Shivesh Singh - Scottish Hospital Development MP10_0160

From: "Sophia Wilson" <sophdwilson@gmail.com>
To: <plan_comment@planning.nsw.gov.au>
Date: 7/12/2010 12:03 AM
Subject: Scottish Hospital Development MP10_0160
CC: <sydney@parliament.nsw.gov.au>, <records@Woollahra.nsw.gov.au>, <scottishhospital@googlegroups.com>, <sharon.armstrong@lands.nsw.gov.au>

STEPHEN STREET ELEVATION

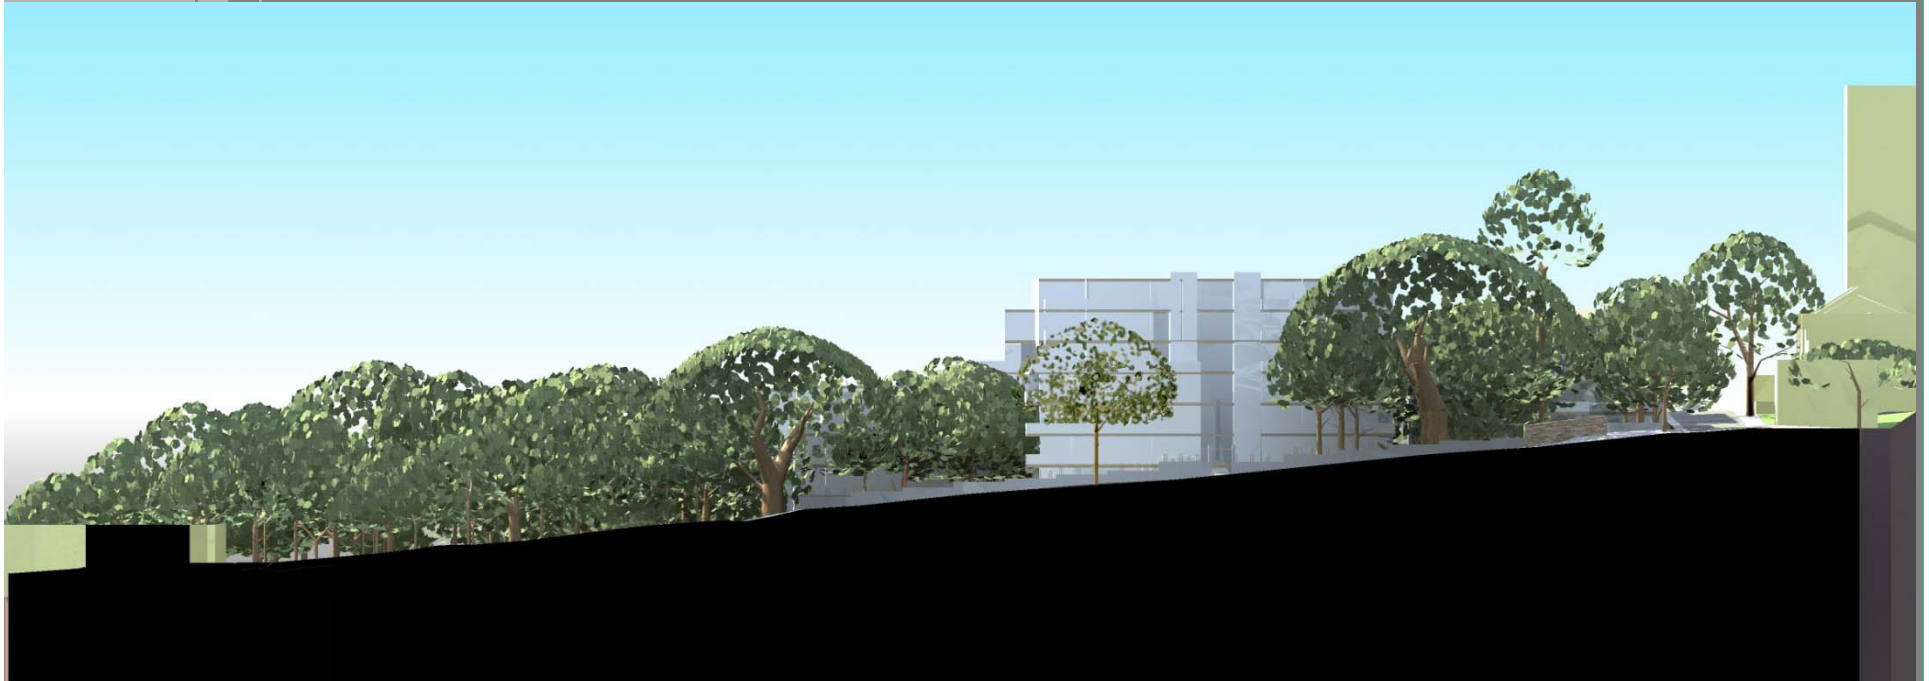
The 6 storey building along the southern end of Stephen Street will create a tunnel effect as it extends past the corner of Glen Street, and ALL the trees are destined to be removed.
